## Engineers Comments Regarding Surface Water Drainage

<b>Application Reference:</b>	P/124/25/PL	<b>Reviewer Reference:</b>	ADC/EXT5/AF
<b>Planning Officer:</b>	Harry Chalk	<b>Date of Review:</b>	4/12/2025
<b>Site Name:</b>	Land to East of Commonmead Barn Pagham Road Pagham PO21 3PY		
<b>Application Description:</b>	2 No single storey detached dwellings (with accommodation in the roof space) along with associated car and cycle parking (resubmission following P/9/24/PL). This application is a Departure from the Development Plan and is in CIL Zone 5 and is CIL Liable as new dwellings.		
<b>Assessment Number:</b>	1

## Reviewed Plans

7.2 **Appendix B – Drainage Layout**

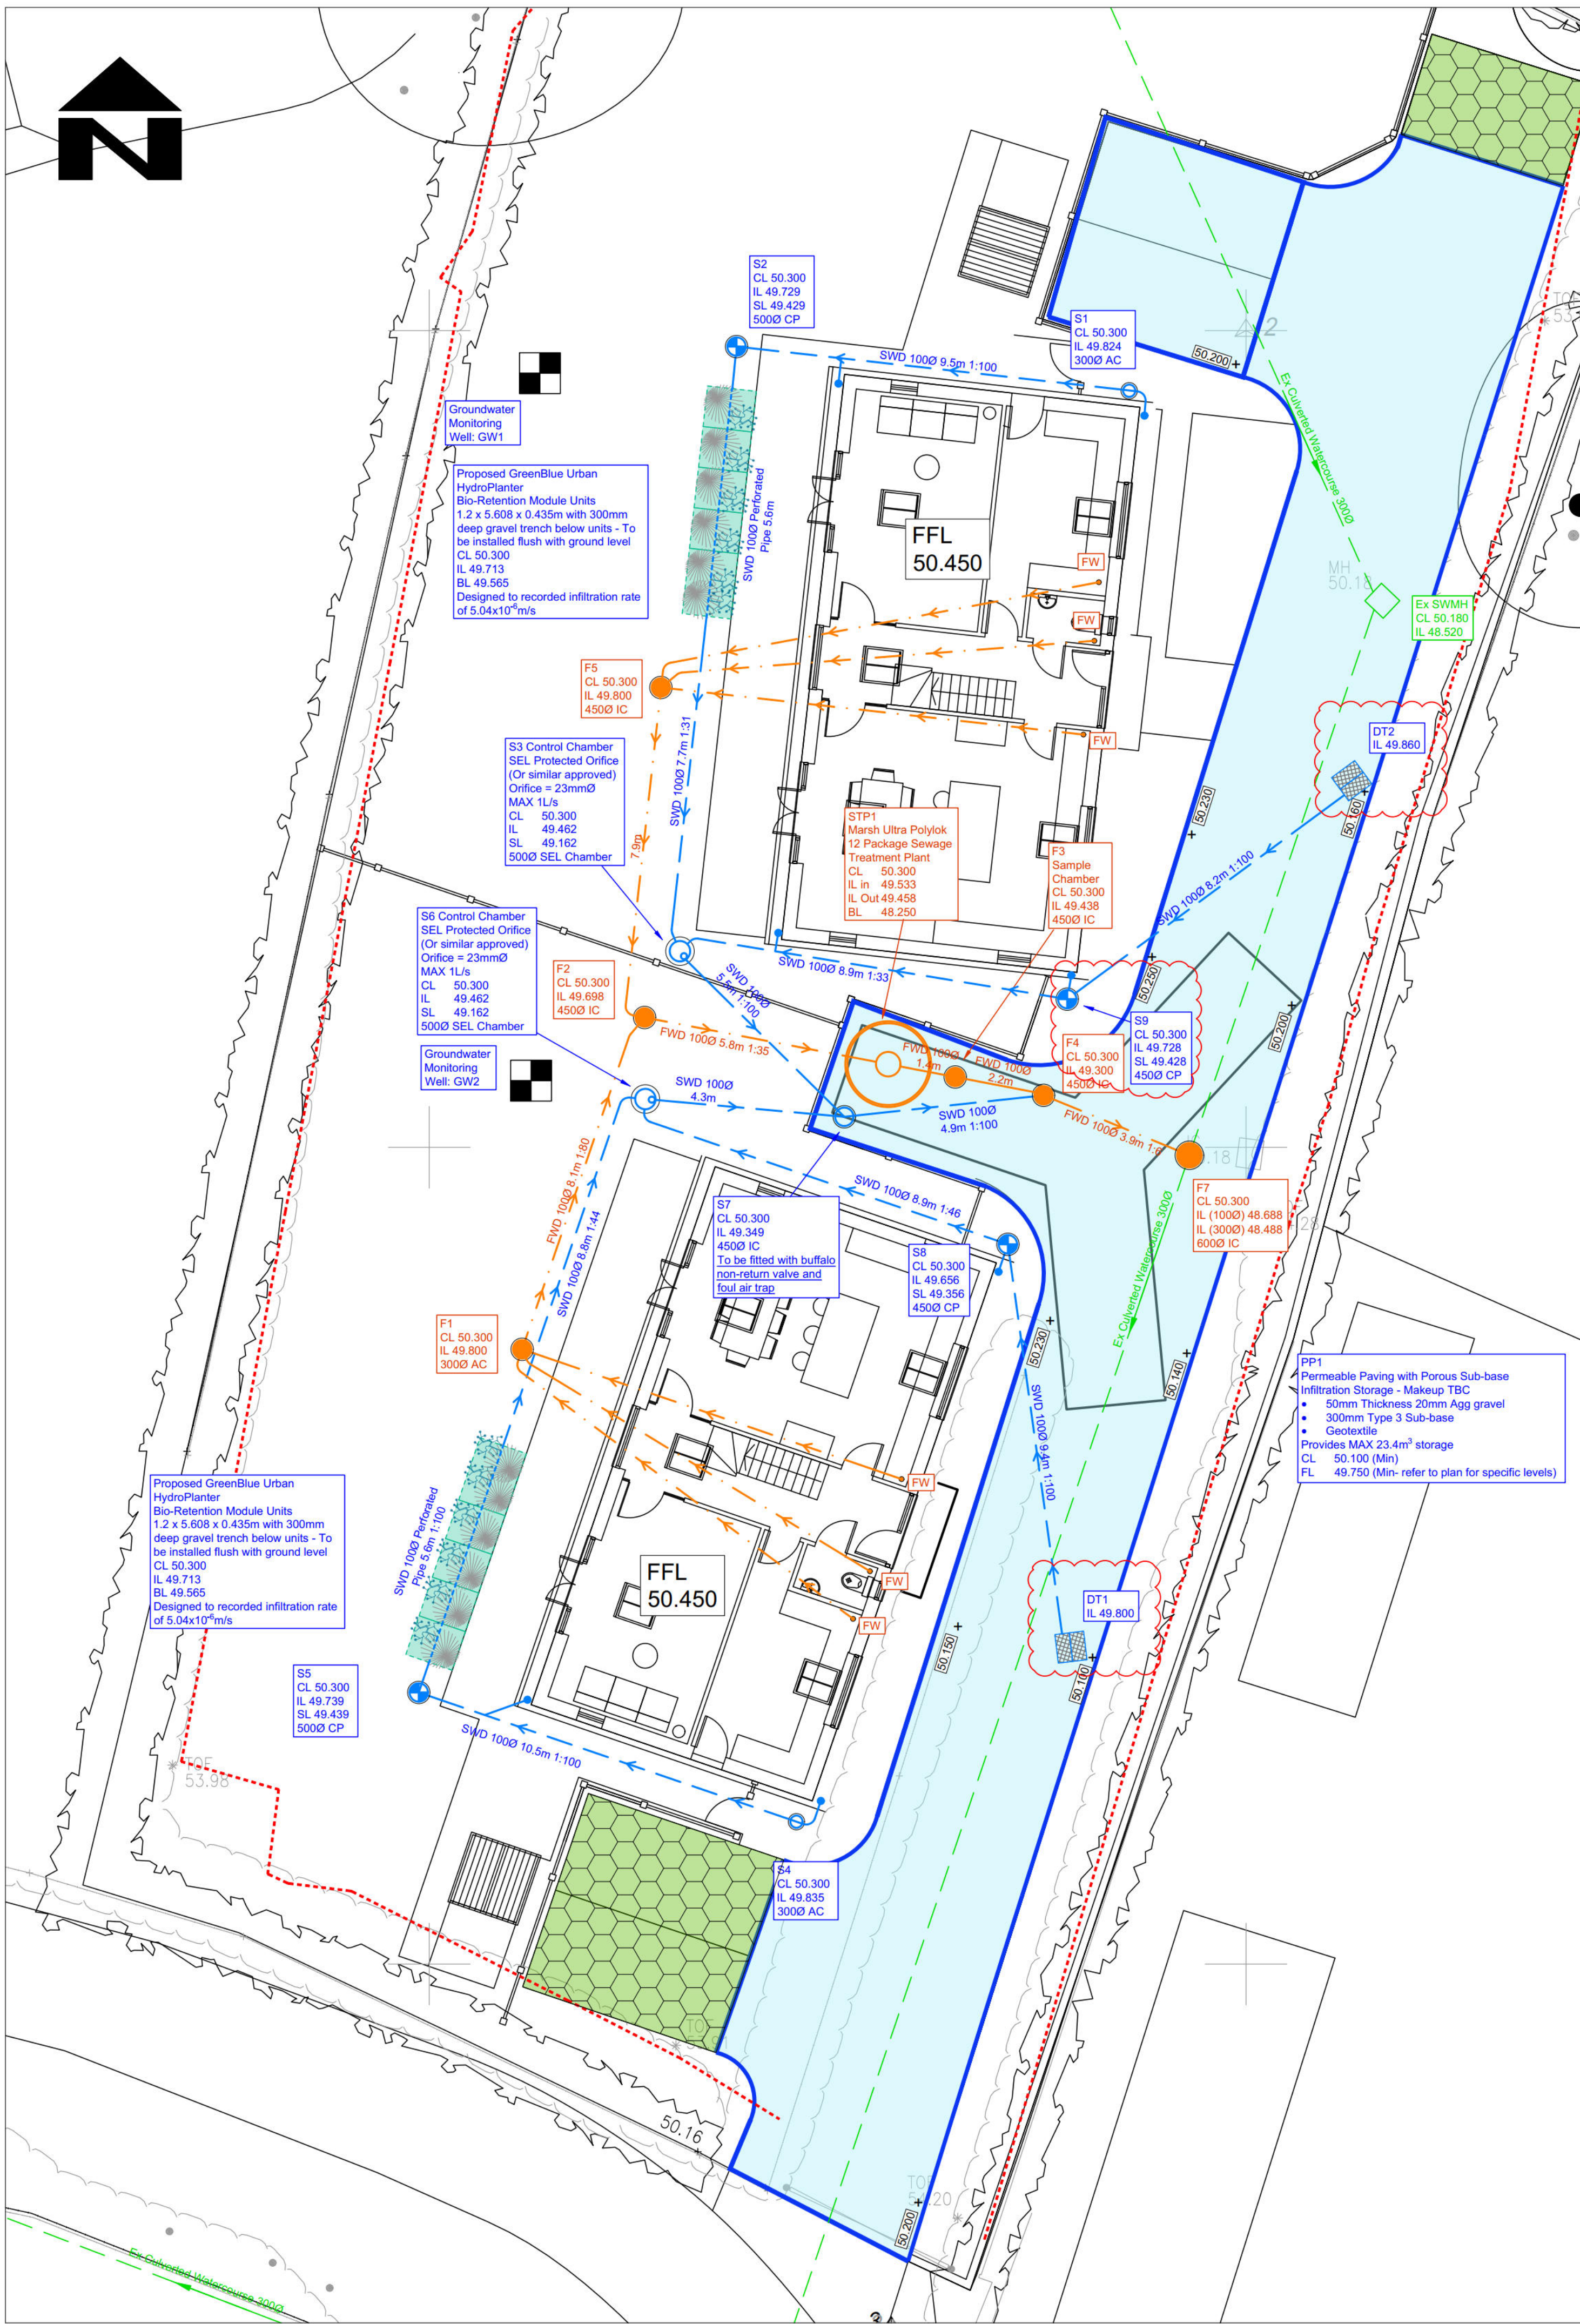
- 1.1. The groundwater monitoring shows winter groundwater levels within 1 metre of the base of the proposed infiltration features. The report notes piped outlets to the onsite culverted watercourse but none are shown on the drainage layout.
- 1.2. The 3m easement for the culverted watercourse should be shown on the plans and may conflict with the proposed building location.
- 1.3. The runoff destination is not currently in accordance with the requirements of the NSfS. Therefore, we **object** to the application.

- 3.2. The drainage layout and calculations are currently based upon an infiltration solution, which is not acceptable due to high groundwater. The report notes connection to the exiting culverted ordinary watercourse at a peak rate of 2l/s. This peak outflow rate is arbitrary and not restricted to greenfield runoff rates in accordance with the National SuDS Standards. Design flow restriction should be based upon greenfield runoff equivalent for the drained area and if necessary a relaxation applied where constraints preclude meeting the GFR rate. Modern flow controls can achieve rates much lower than 1l/s with adequate blockage mitigation incorporated.

- 3.3. A drained areas plan should be provided. It is noted that the urban creep allowance is incorporated into the model simulations.
- 3.4. The infrastructure within the permeable paving storage may reduce the available capacity and any significant chambers and any utilities margin should be removed from the plan area / volume calculation.
